CITY OF ALBUQUERQUE

Aug 24, 2018

Re: New Office Warehouse Facility
7000 Huseman Place SW Albuquerque NM
Traffic Circulation Layout
Engineer's/Architect's Stamp 08 – 08 - 18 (M10-D016J)

1 PARKING LOT LAYOUT PLAN
3 1"=20'

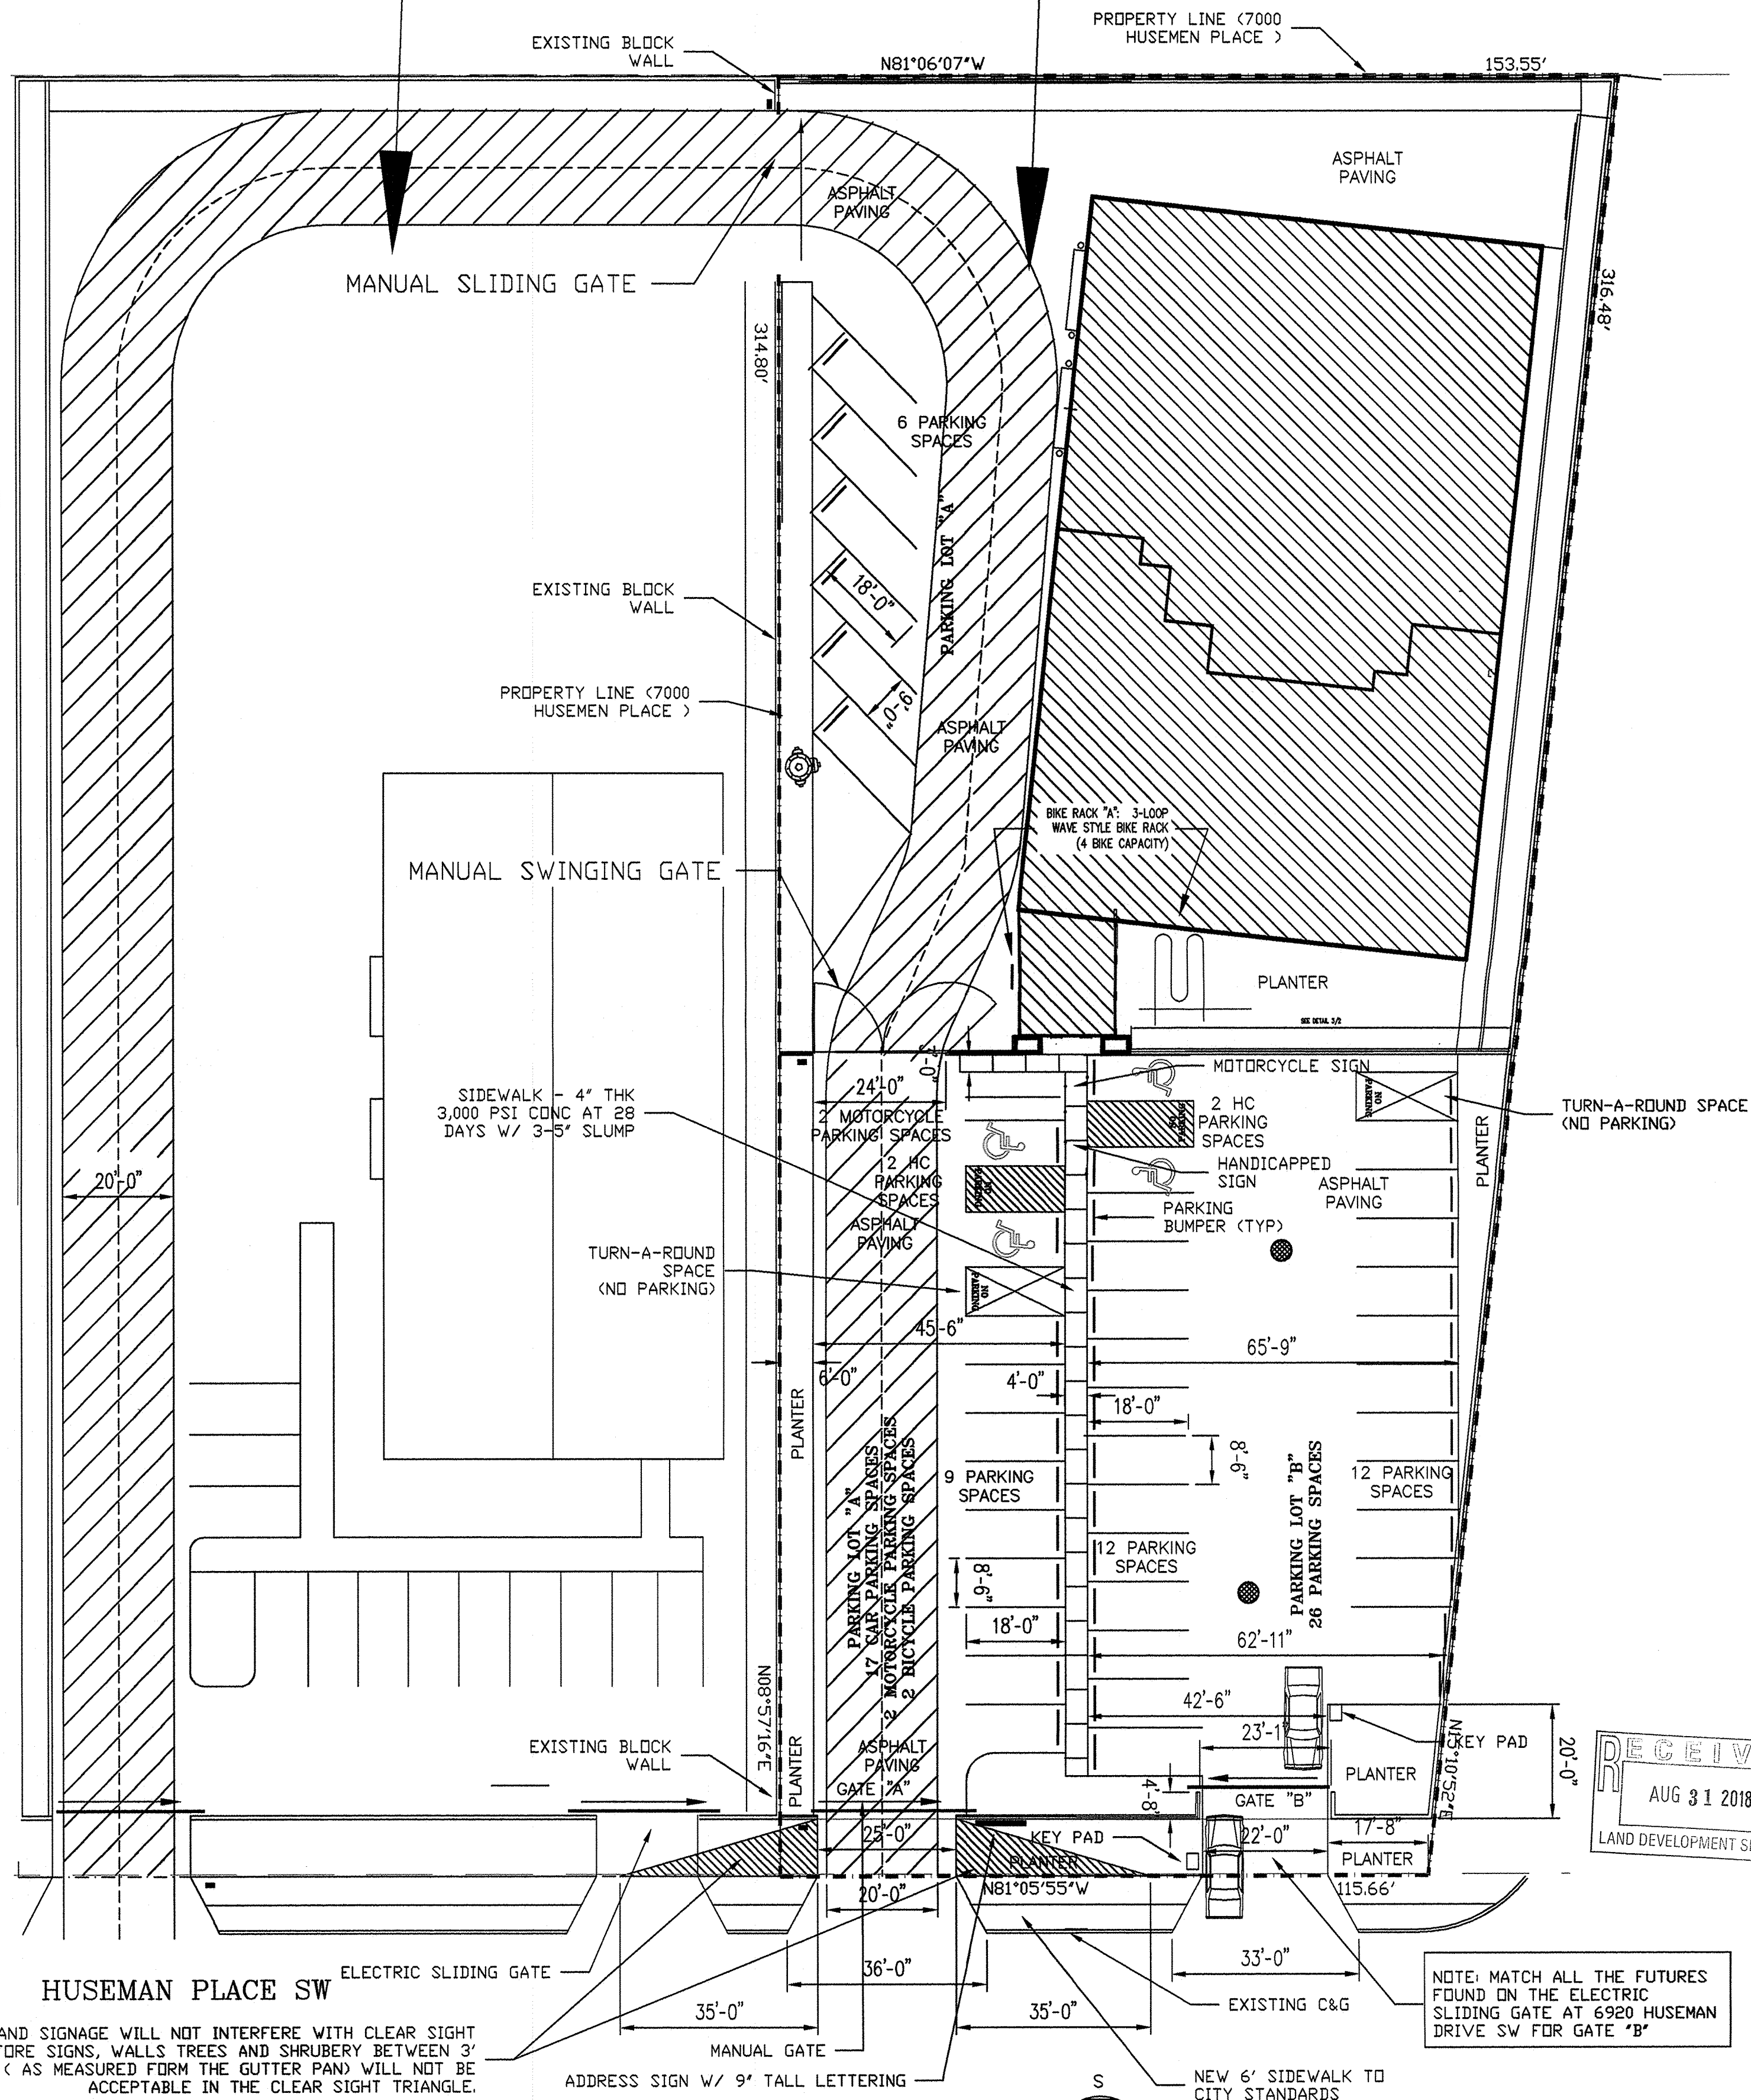
1. Please show a vicinity map showing the location of the development in relation to streets and well-known landmarks.
2. The ADA access aisles shall have the words **"NO PARKING"** in capital letters, each of which shall be at least one foot high and at least two inches wide, placed at the rear of the parking space so as to be close to where an adjacent vehicle's rear tire would be placed. (66-1-4.1.B NMSA 1978)

3. Motorcycle parking spaces shall be designated by its own conspicuously posted upright sign, either free-standing or wall mounted per the zoning code.

4. Show the clear sight triangle and add the following note to the plan:
"Landscaping and signage will not interfere with clear sight requirements. Therefore, signs, walls, trees, and shrubbery between 3 and 8 feet tall (as measured from the gutter pan) will not be acceptable in the clear sight triangle.

5. Identify all the curb cuts widths. Two of them do not have dimension.
6. Provide a shared cross access agreement between two properties.
7. Clarify existing property lines and proposed property lines.

8. The drawing for the distance between two curb cuts is different in two provided sheets. Please clarify!
